# ENG-SF22013-R1-GEC.pdf Markup Summary

**Subject:** Stamp - Stormwater Comment Legend  
**Page Index:** 1  
**Date:** 5/12/2022 1:05:52 PM  
**Author:** Glenn Reese - EPC Stormwater  
**Color:**   
**Layer:**  
**Space:**  
**Page Label:** [1] 1 CV\_01- Grading - CV01

**Subject:** Polygon  
**Page Index:** 2  
**Date:** 5/11/2022 6:15:05 PM  
**Author:** Glenn Reese - EPC Stormwater  
**Color:**   
**Layer:**  
**Space:**  
**Page Label:** [2] 2 GR\_01 - GR01

COVER SHEET

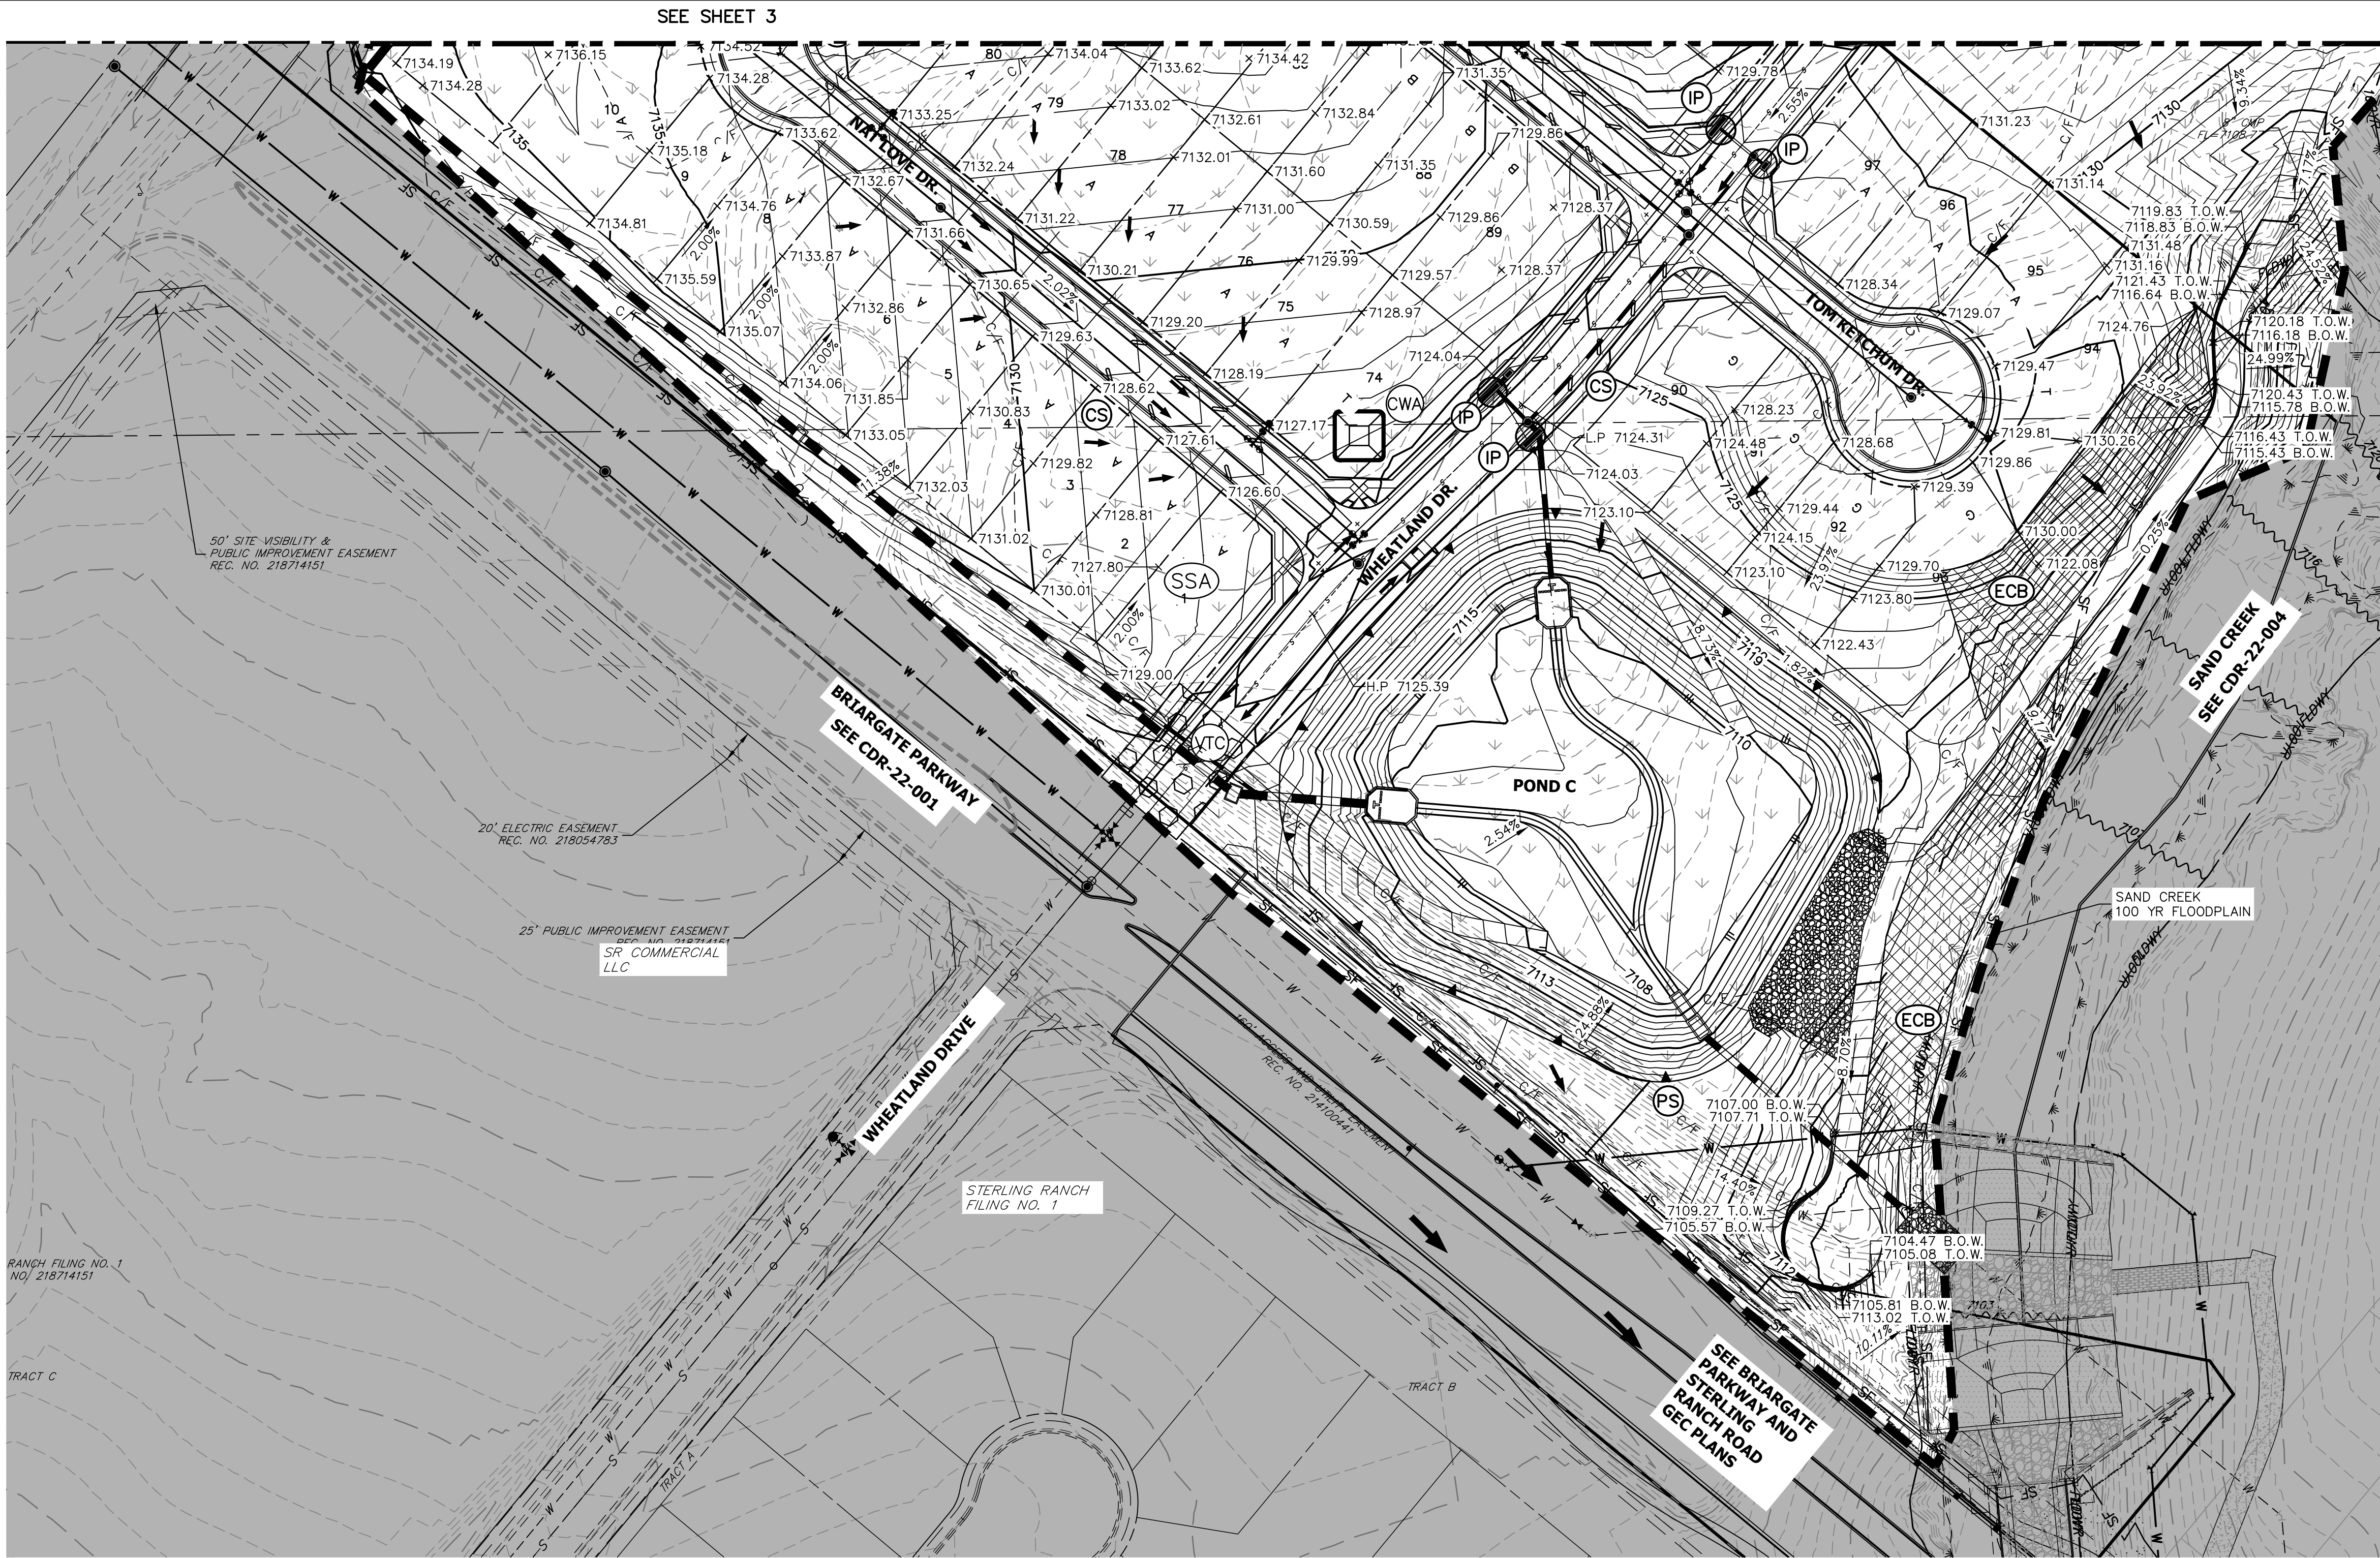
See comment letter also.
